Current Zoning: UMUD-O SPA (uptown mixed-use district, optional, site plan amendment)
 Proposed Zoning: UMUD-O SPA (uptown mixed-use district, optional, site plan amendment)

Approximately 1.48 acres located at the east side of the intersection of South Church Street and West Brooklyn Village Avenue, along the northwest side of South Tryon Street.

The petition proposes to allow two 1,880 square foot skyline signs. The site is developed with an office tower.

G01-01

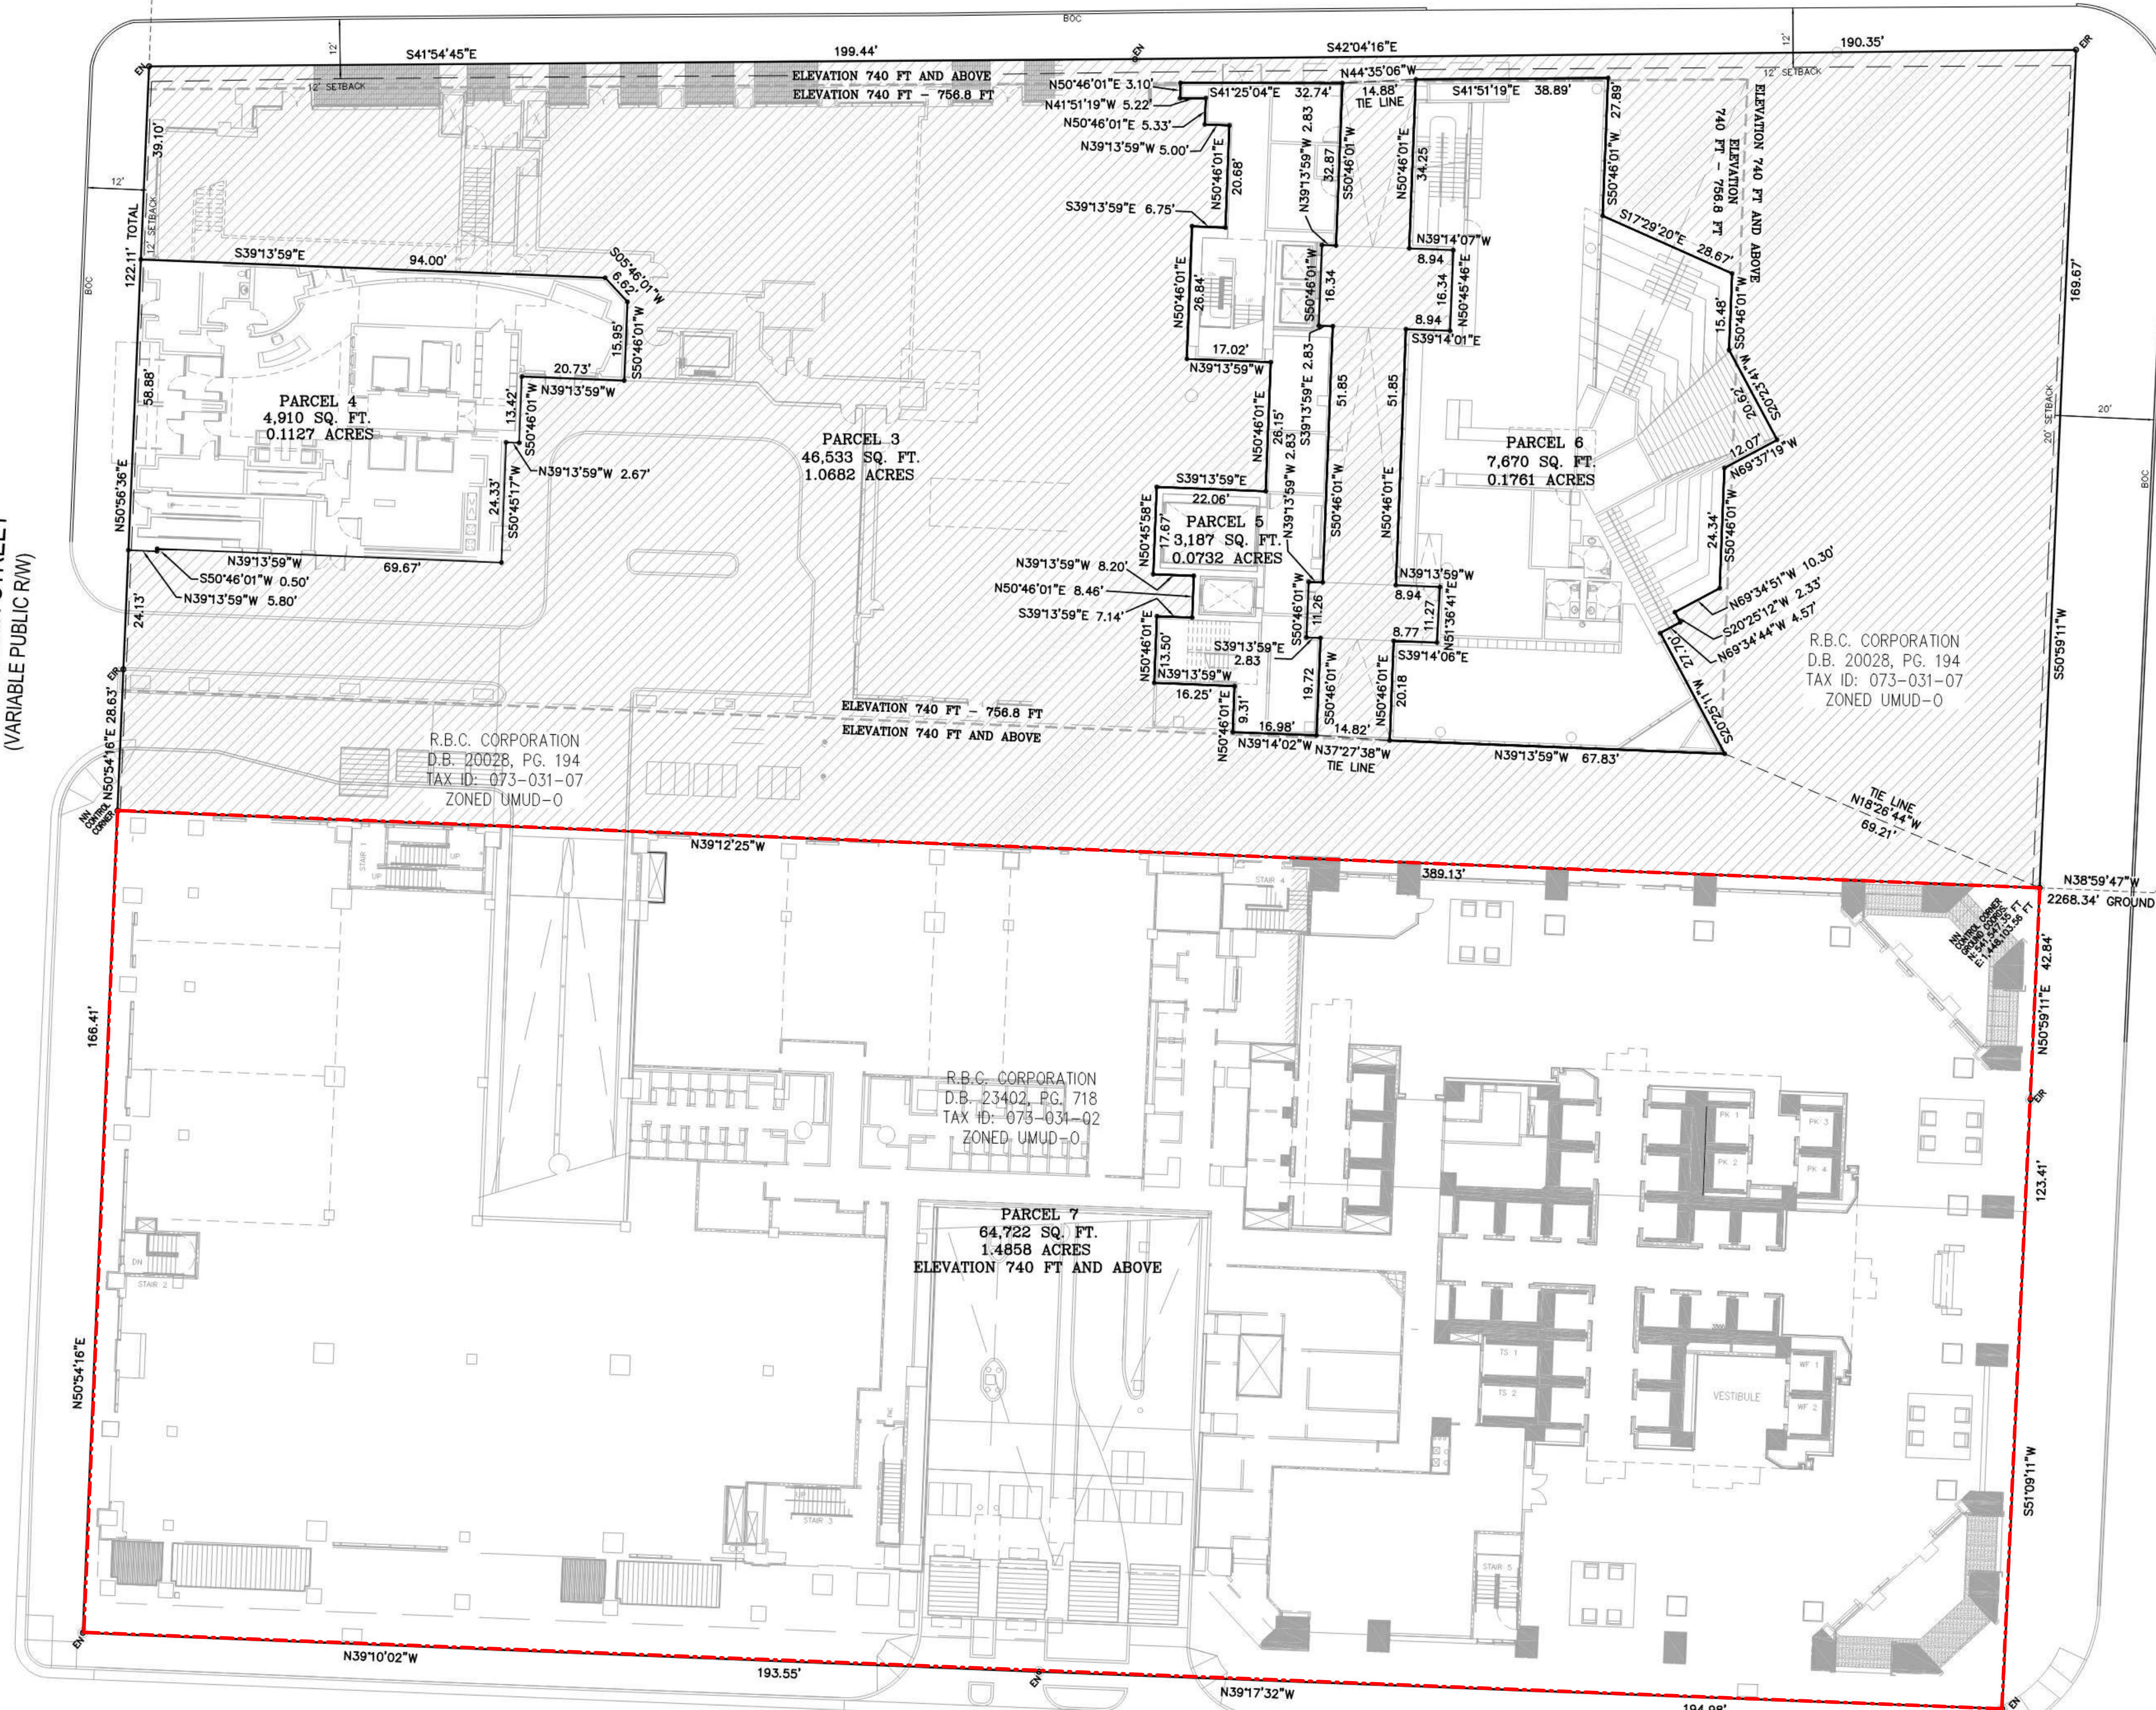
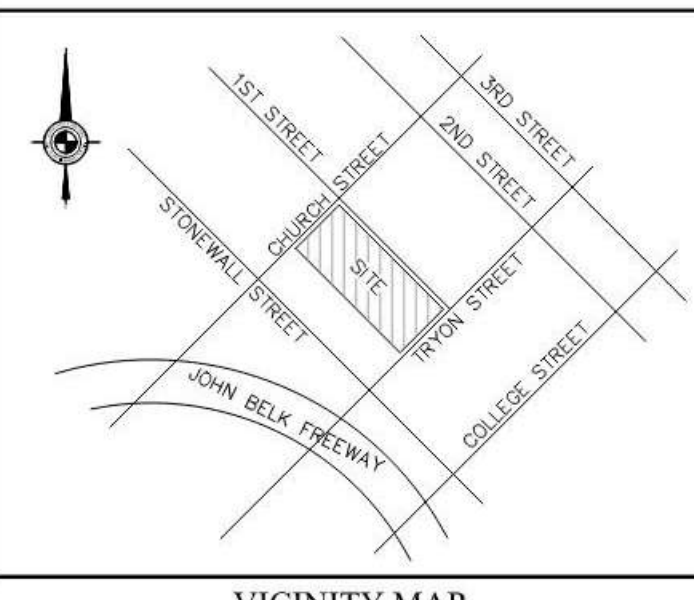
- ~~1. Update proposed optional provisions to specify that the requested skyline sign be made up of channel letter construction.~~ **ADDRESSED**
-
